NOTES ADDED IN RED IN  
RESPONSE TO CONDITIONS OF  
CONSENT

LORETO NORMANHURST  
BOARDING HOUSE  
91-93 PENNANT HILLS ROAD  
NORMANHURST, NSW 2076

Drawing Title
BASEMENT PLAN
Sheet Status
NOT FOR CONSTRUCTION

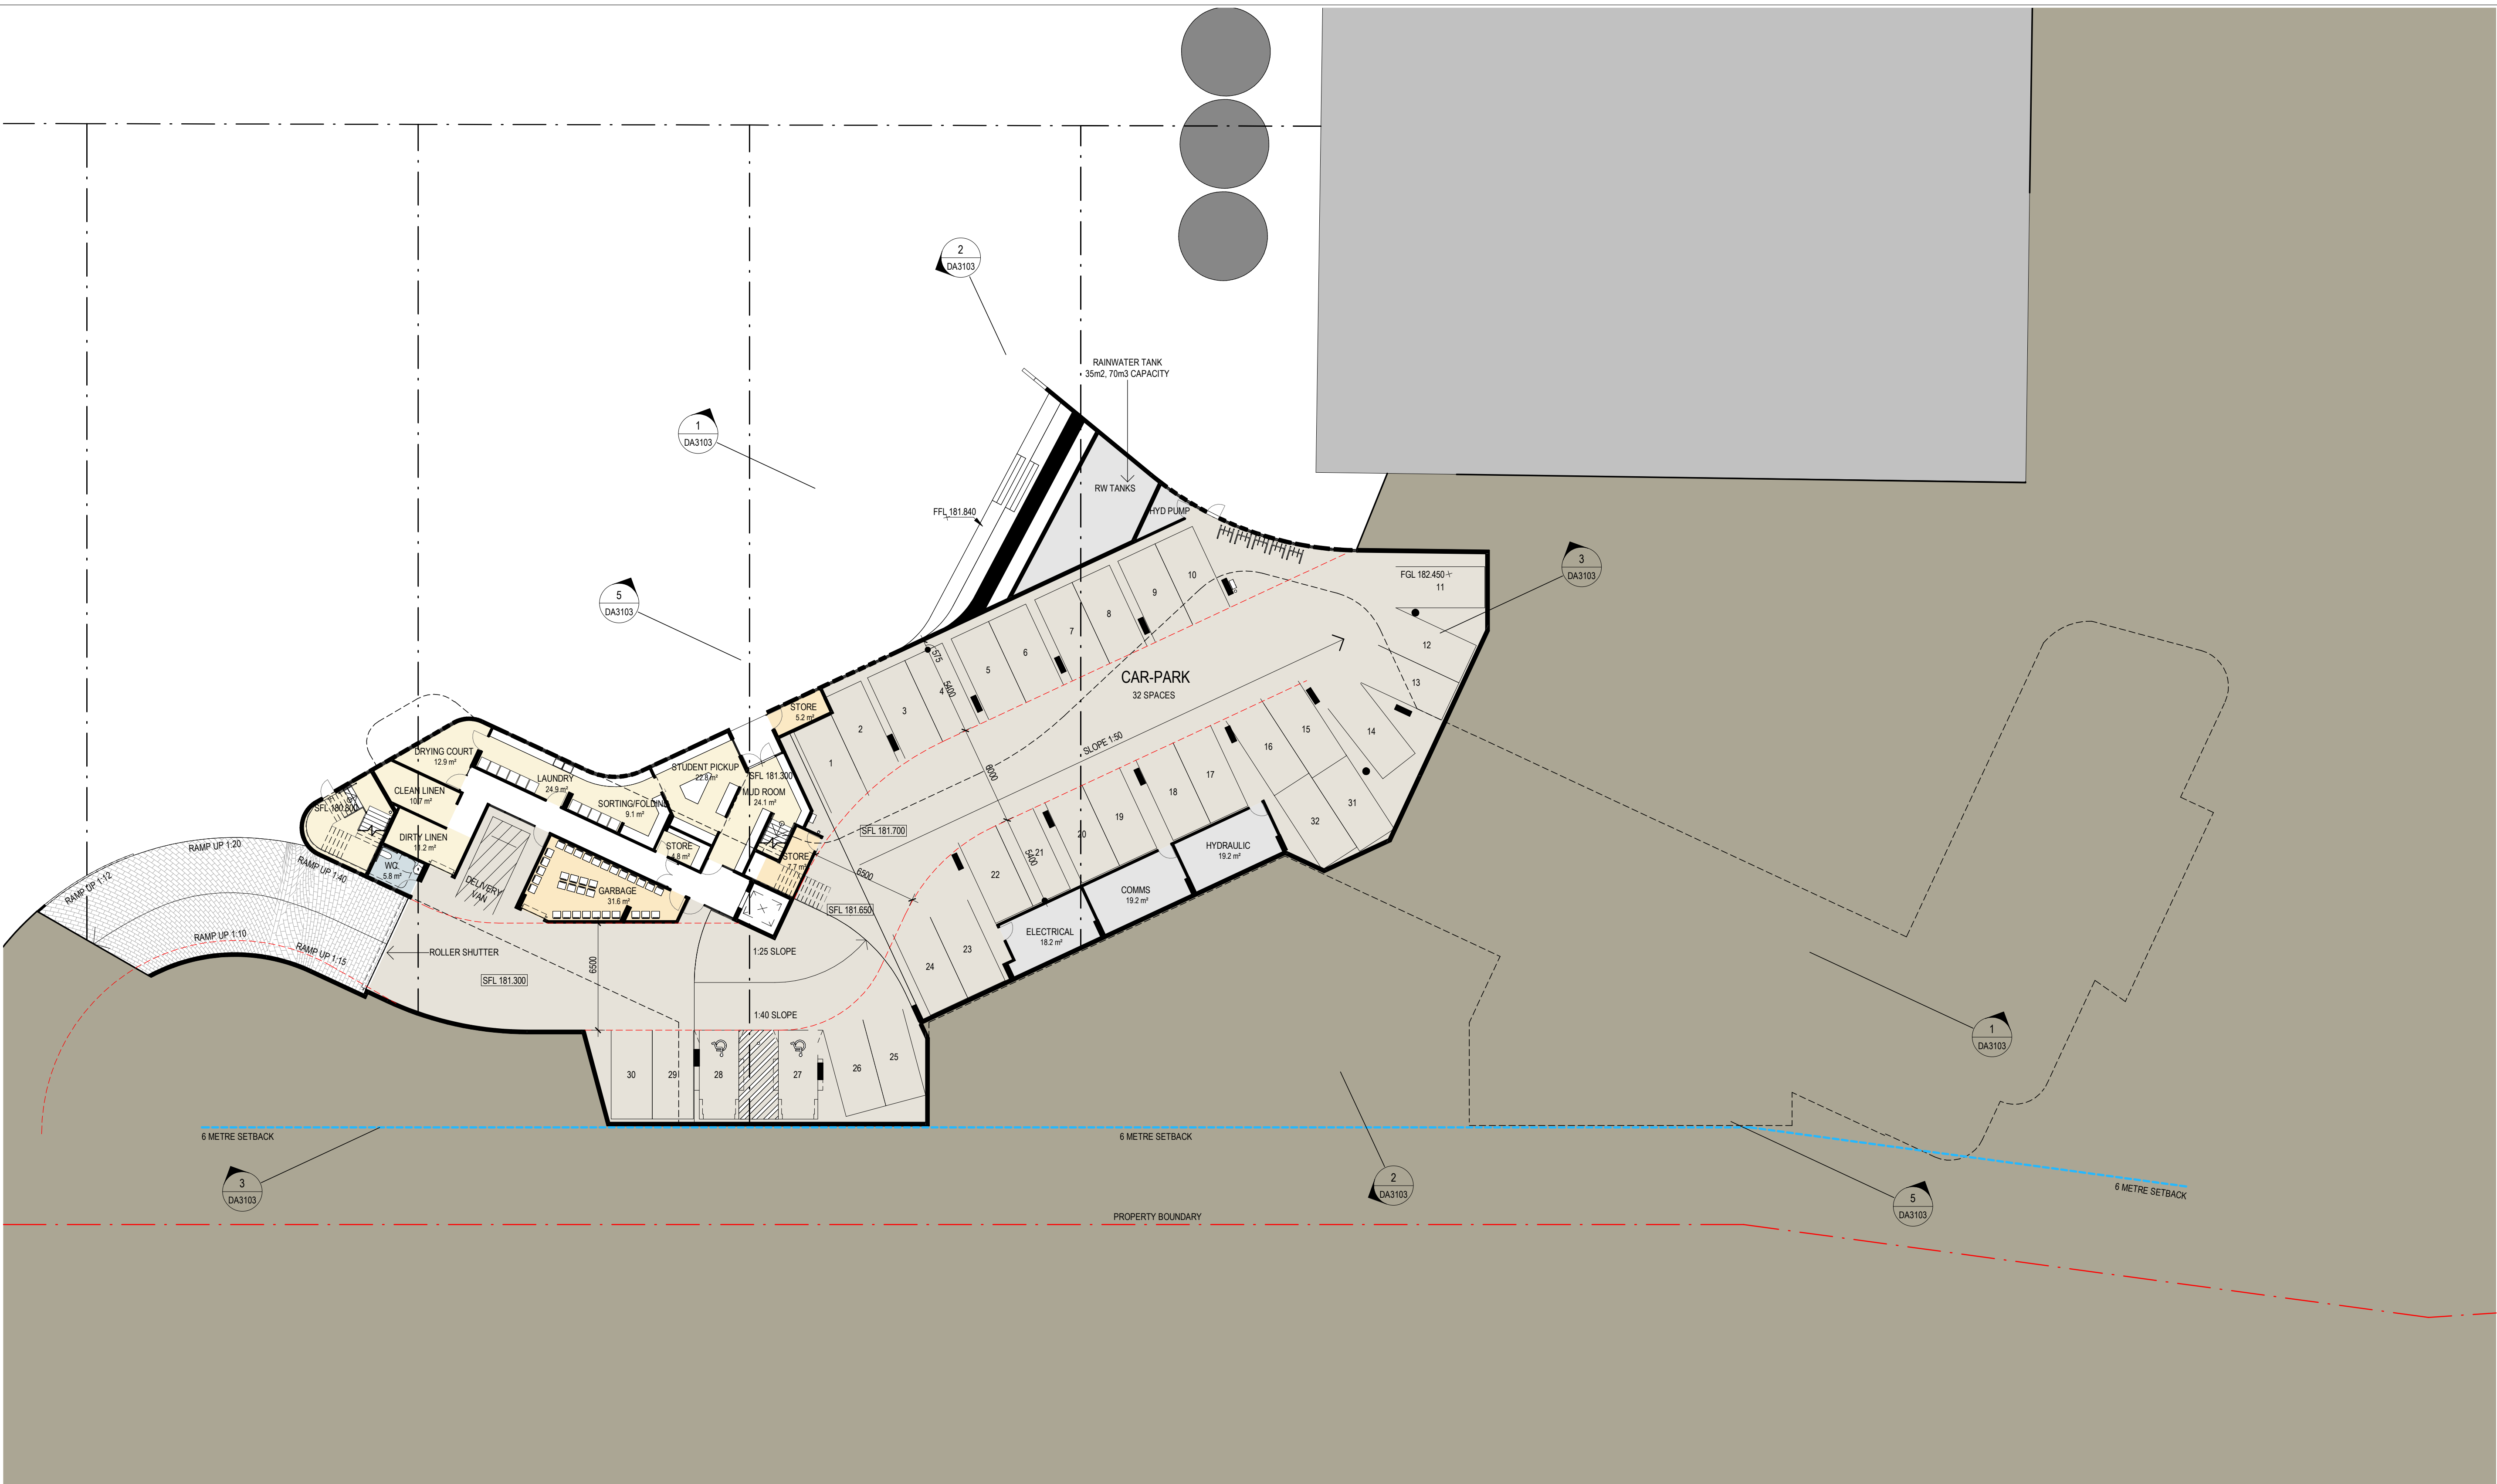
DRIVEWAY TO BE  
REDESIGNED TO  
ACCOMODATE LOWER  
BASEMENT RL

EXTENT OF PREVIOUS SSDA SCHEME IN RED  
GARBAGE AREA TO BE  
RELOCATED TO BASEMENT

Drawing Title
LEVEL 1 PLAN

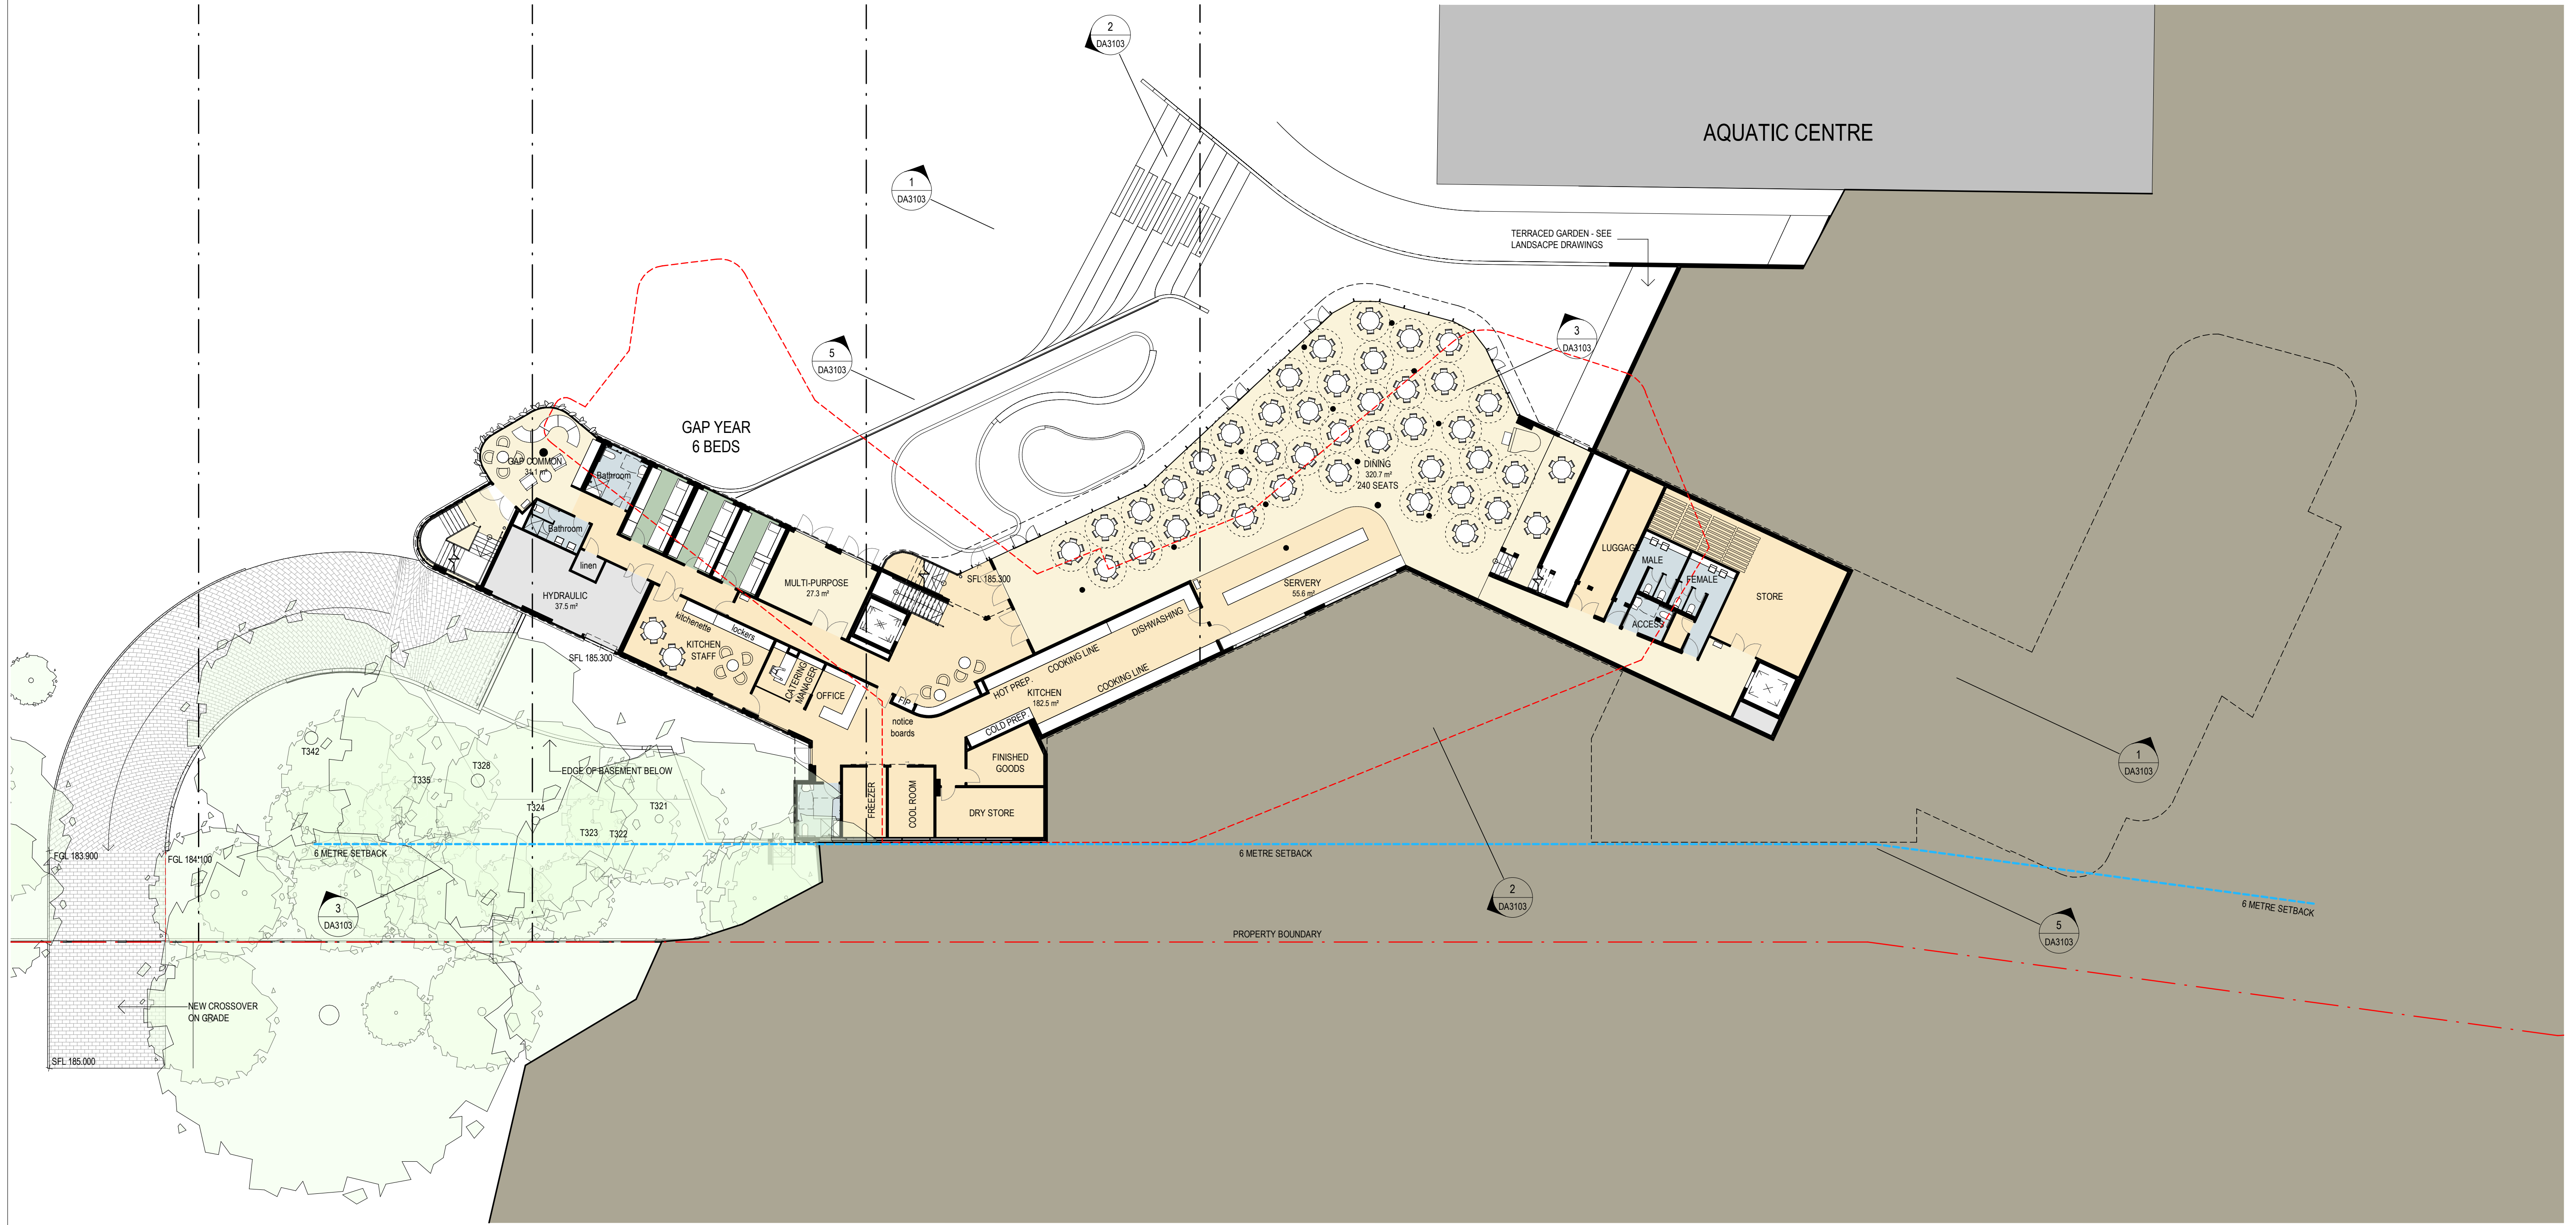
LOADING DOCK AND DRIVEWAY REMOVED  
AND RETENTION OF TREES T227, T321, T323,  
T324, T328, T331, T335, T336, T337
